SBS CONSTRUCTION AND ENGINEERING, LLC

RE: Vacation of Public Alley North of Lot 6, Block 2, Davis Addition
Locust St., SE, Containing 0.0723 Acre, Zone Atlas Page K-14-Z

DEVELOPMENT REVIEW BOARD – SPEED MEMO

DRB CASE NO: 1009977

809 LOCUST STREET, S.E.
(60' R/W)

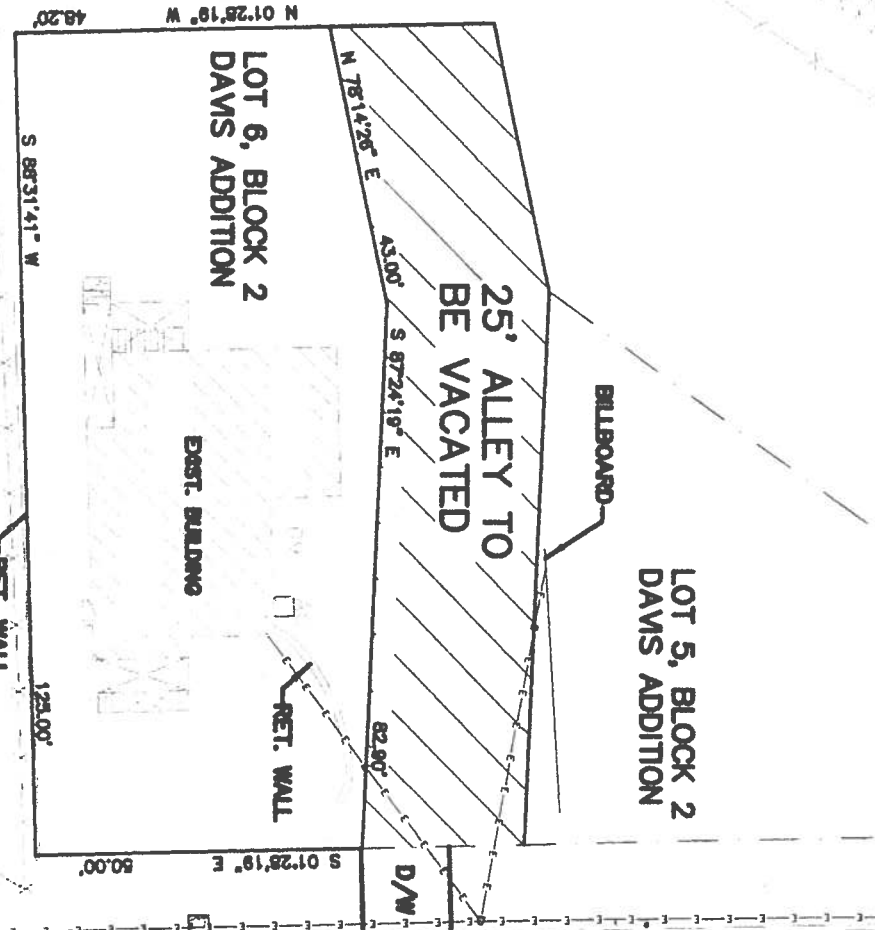
Based on the NMDOT comments provided, Transportation Development does not support this vacation request. Please clarify the differentiation between City of Albuquerque and NMDOT jurisdiction. The City of Albuquerque may only vacate right of way under their jurisdiction.
